**Consultation Response from KC,
Conservation & Design****2024/91199 140A, Manchester Road, Longroyd Bridge, Huddersfield, HD1 3JA****Demolition of existing building and erection of student accommodation with ancillary spaces,
associated garden area, store and landscaping, access and car parking****Date Responded: 10.06.2024****Responding Officer: S Pickles****Responding Ref:**

SITE PLAN Scale 1:100 0 5m 10m

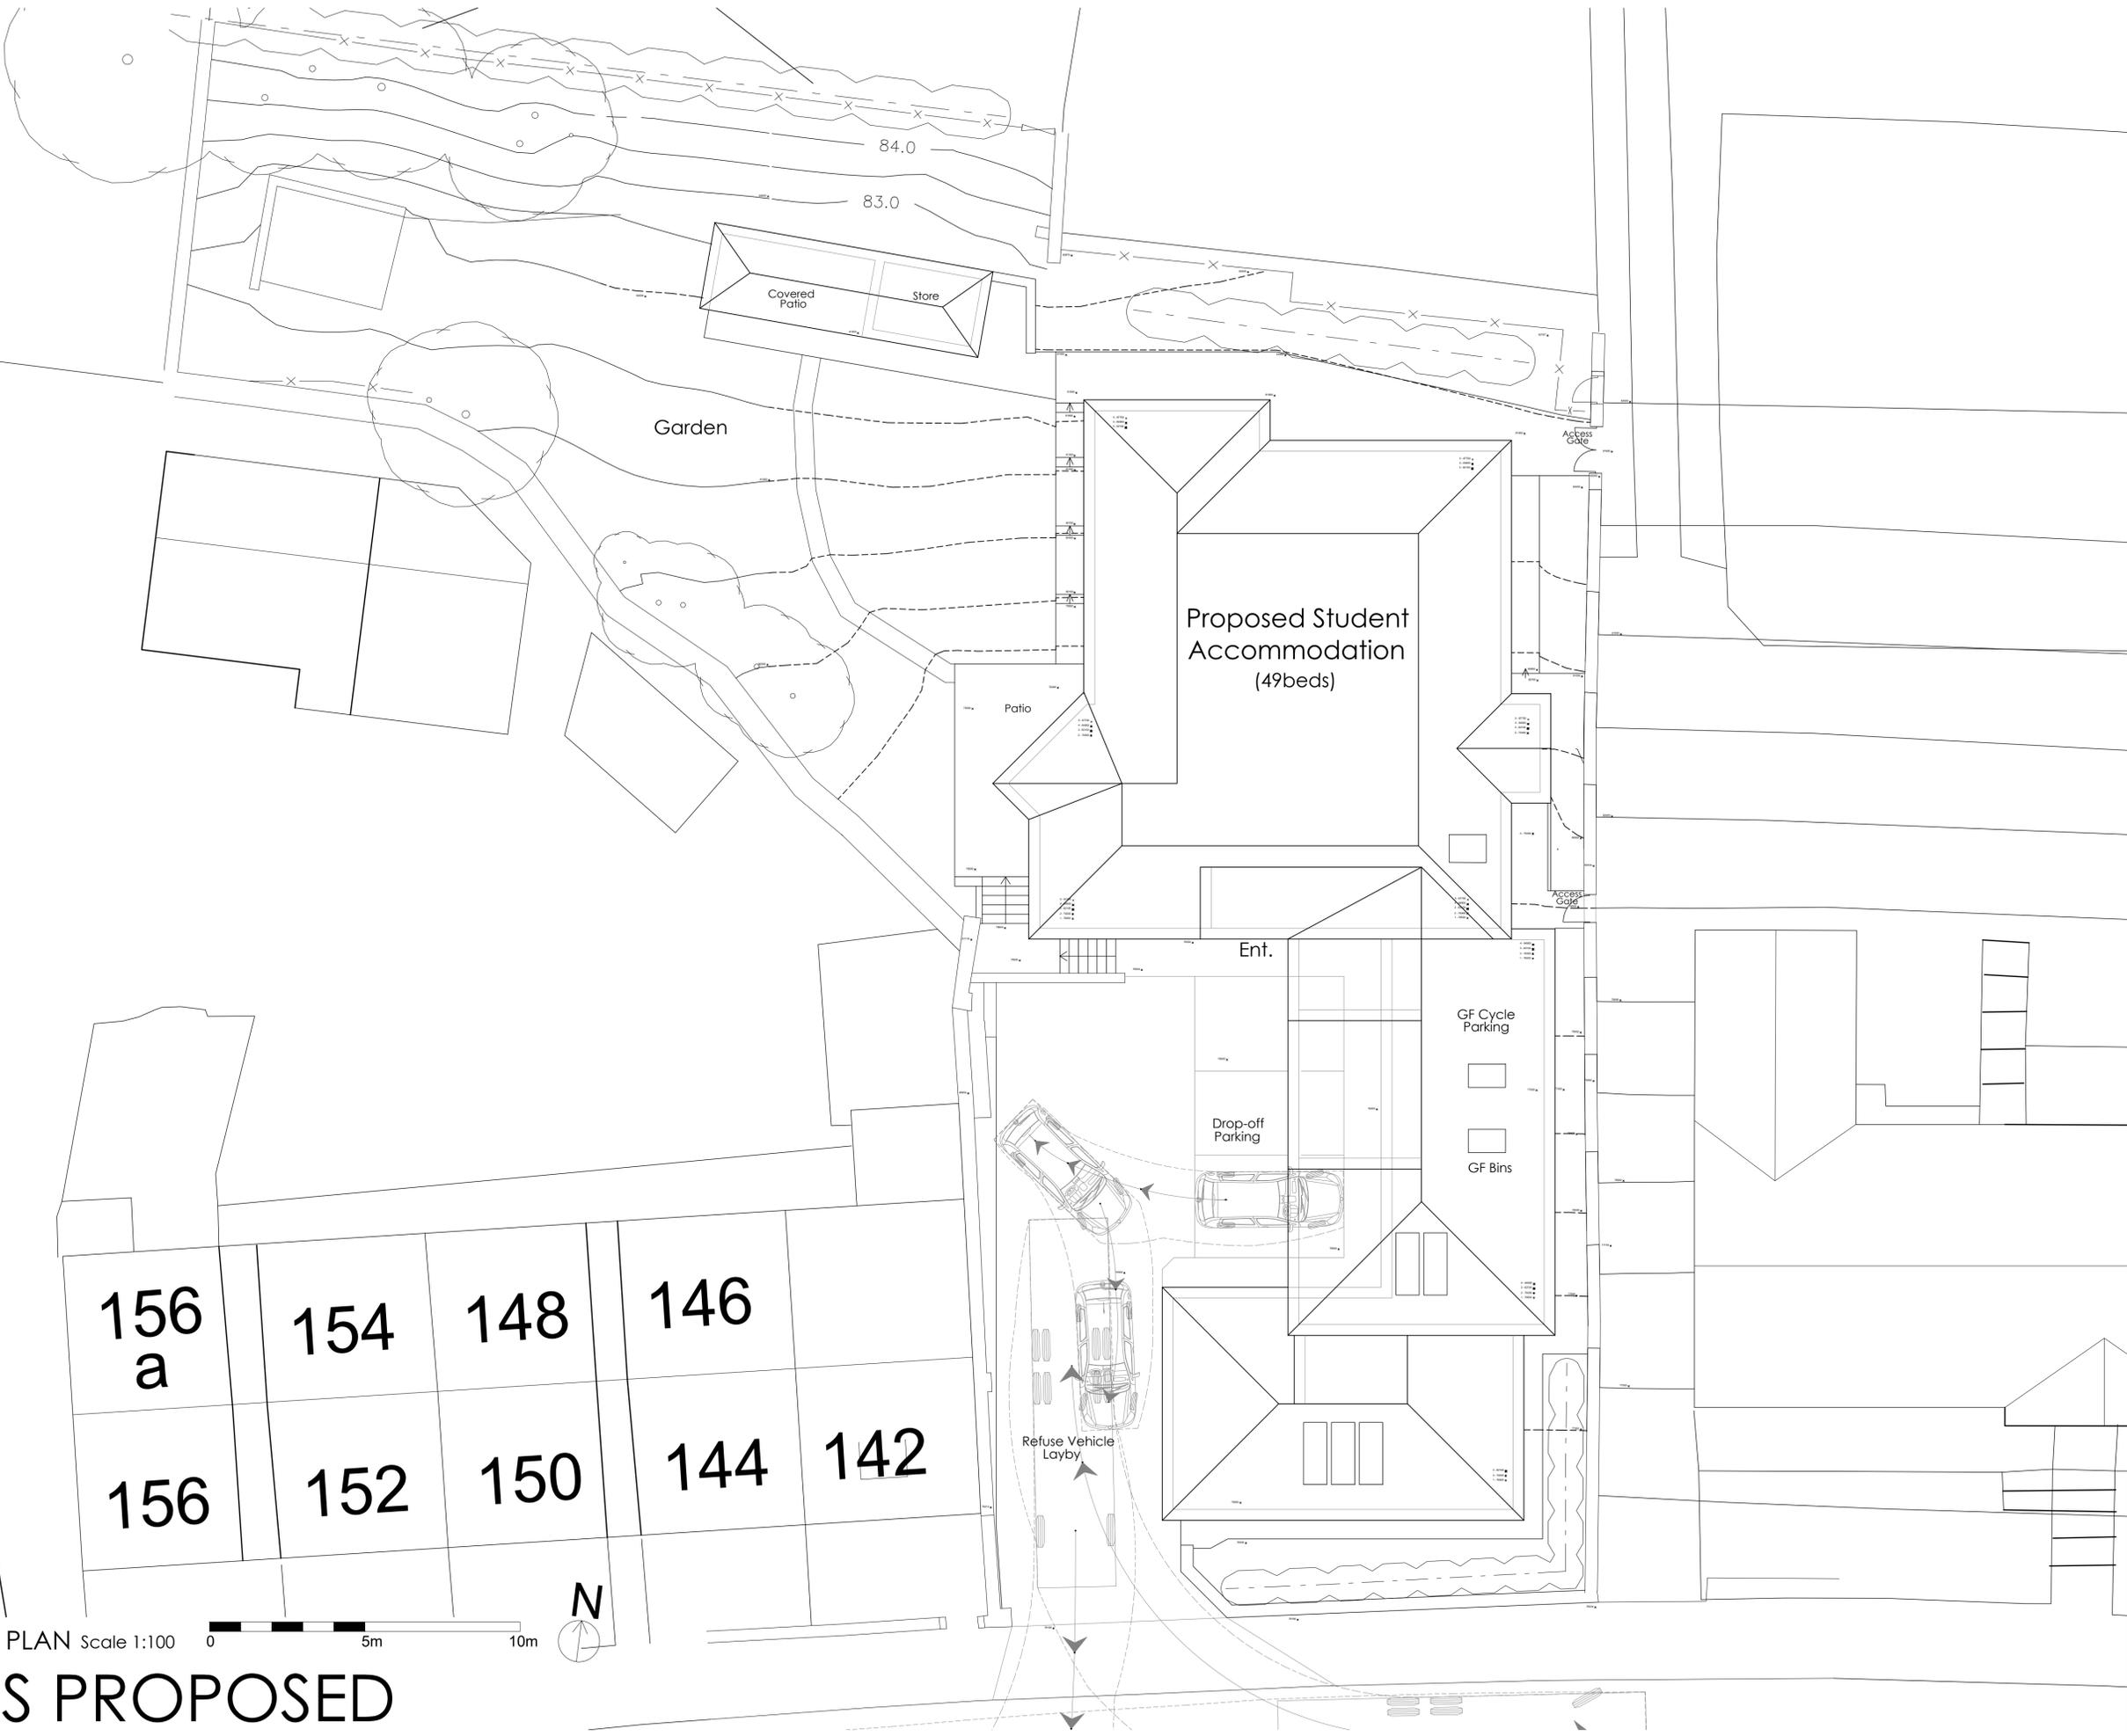
The proposed development would near enough fill the plot and also extend further back. The development would entirely interrupt the views and appreciation of Spring Lodge 14-15 Woodthorpe Lodge and have a significantly harmful impact on their setting and the historic grounds associated with Spring Lodge.

GA ELEVATIONS
 AS PROPOSED

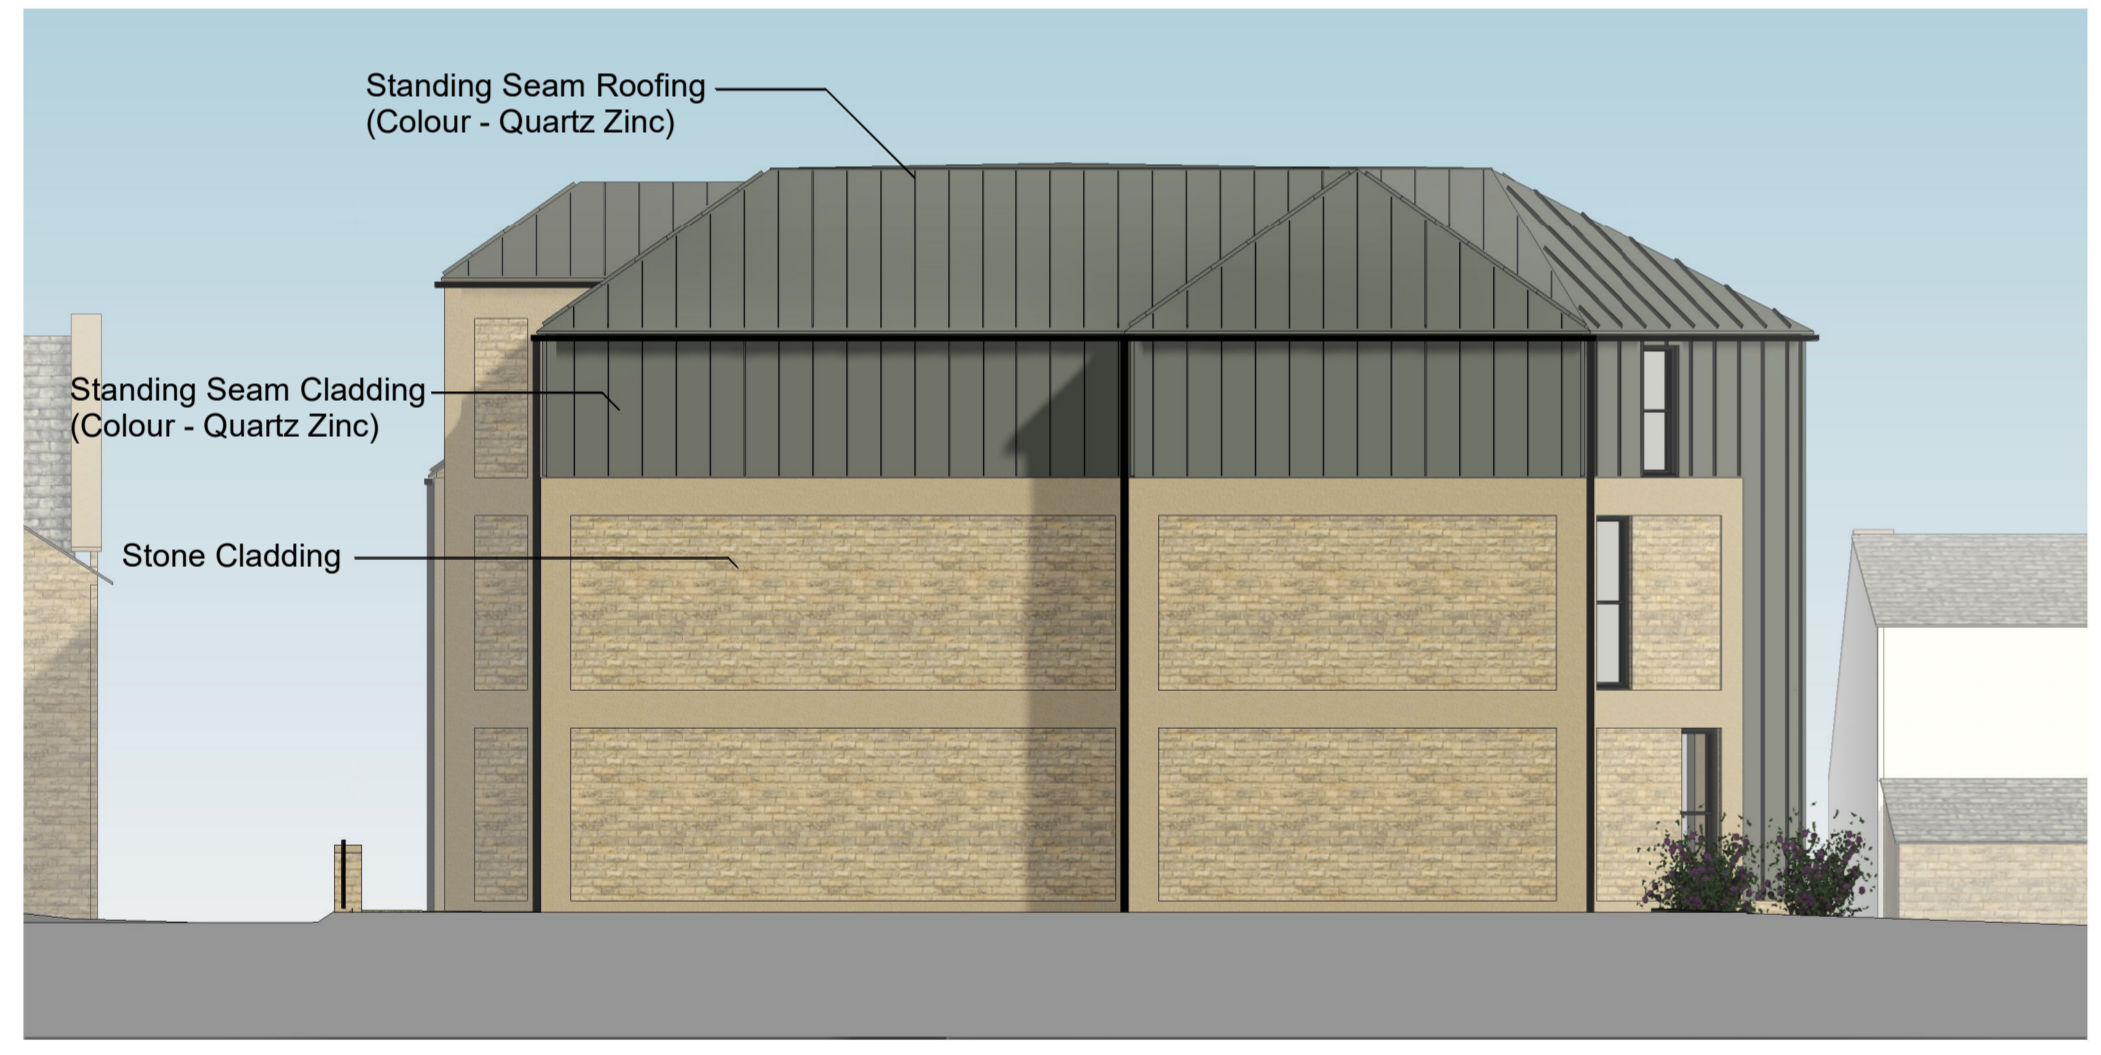
In consideration of the impact on the listed buildings 160, 162 and 164 Manchester Road. While the site is detached from the site, the Listed Buildings are experienced off Manchester Road when looking along Manchester Road from the west and the east. The proposed development is of a considerably greater height and scale than the existing surrounding development. The development would be clearly visible in long views along the row of terraces. The submitted statement tries to set out that with similar and contemporary materials, maintaining a strong continual eave line and simple façade with pitched roofs that the proposals reflect and respect the character and setting of the listed buildings. We would disagree with the assessment, which is subjective. While the building may make use of similar materials, the design elements are entirely incongruous and in no way reflect the character or setting, even in a contemporary style.

Conservation and Design object to the proposed development. We consider that the development would have a harmful impact on the setting of the Grade II Spring Lodge and Grade II 14-15 Woodthorpe Terrace. The development would also have a harmful impact on the wider setting of the Grade II 160, 162 and 164 Manchester Road as it would create development which is disproportionate and incongruous with the streets scene and setting.
